<b>Consultation Response from KC, Highways Development Management</b>		
<b>2021/92528 Land off, Bankwood Way, Birstall Retail Park, Birstall, Batley, WF17 9DT</b>		
<b>Erection of retail development, associated parking, servicing areas and landscaping.</b>		
<b>Date Responded: 04-10-2021</b>	<b>Responding Officer: Mark Berry</b>	<b>Responding Ref: 13-9-1</b>

Bryan G Hall Ltd. Registered in England & Wales Co No. 4104802

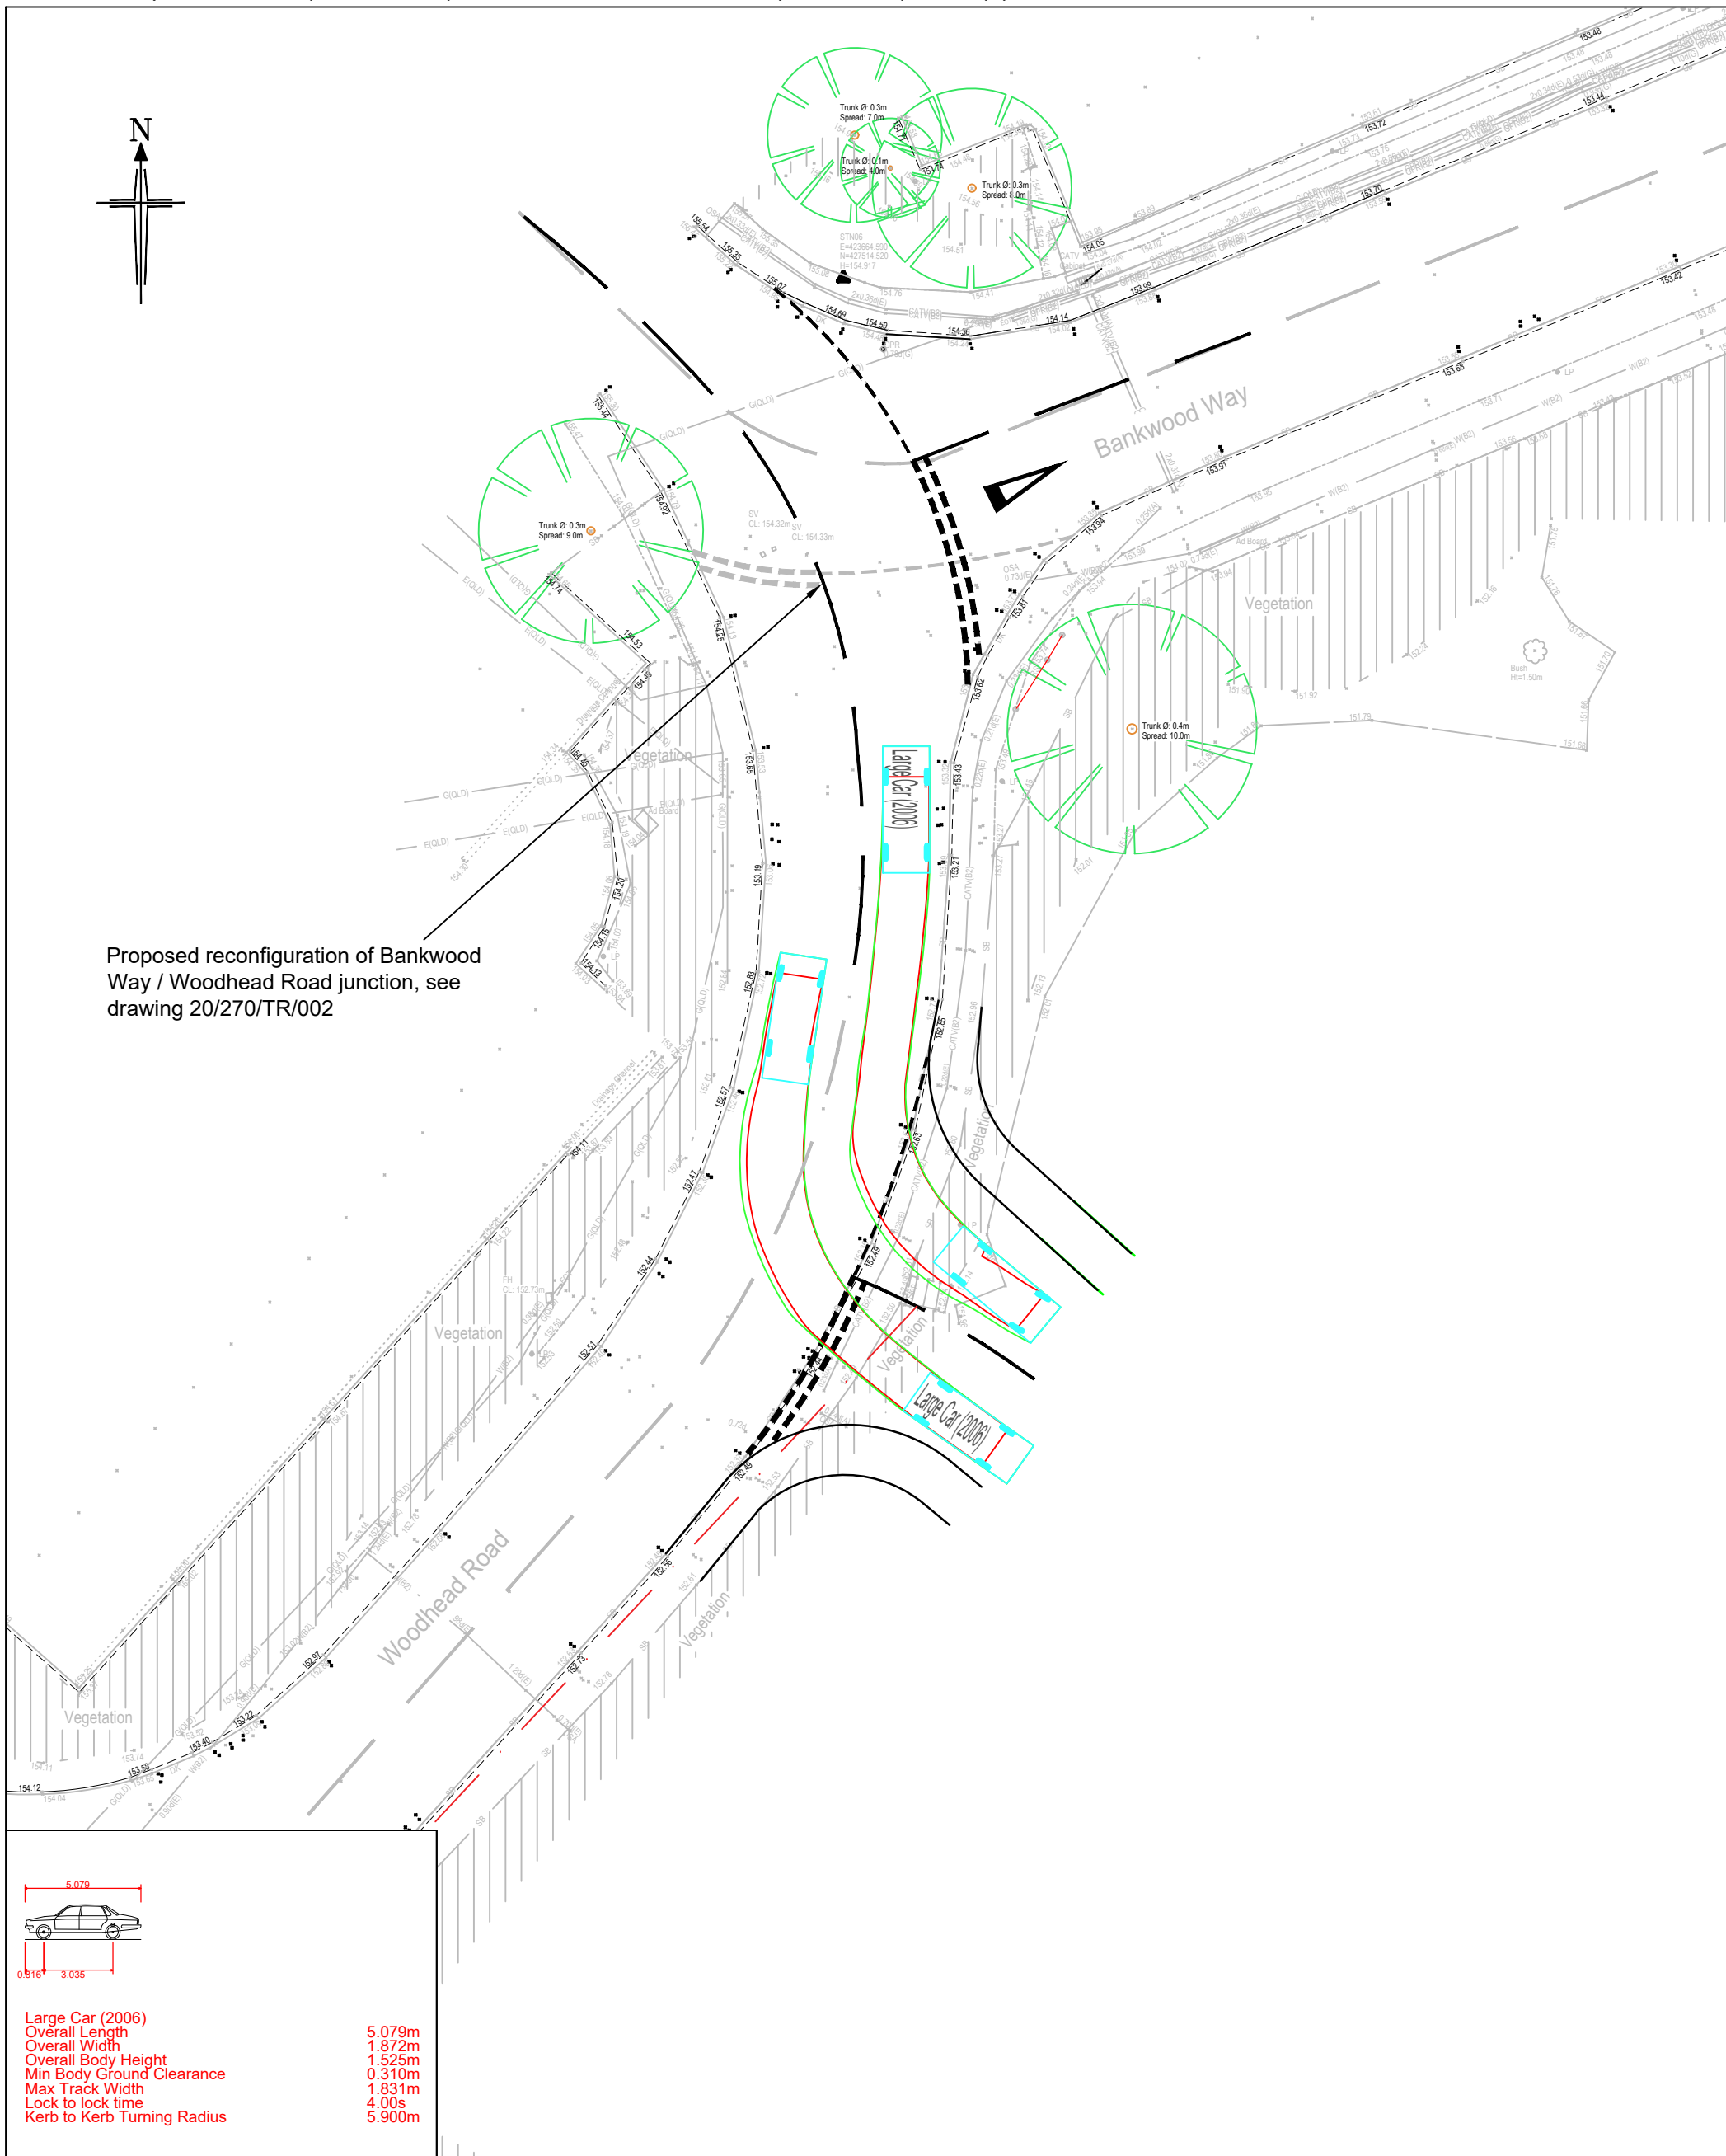
1, The tracking drawing is unclear with HGV turning movements tight and or over-running kerb kerblines on Bankwood Way.
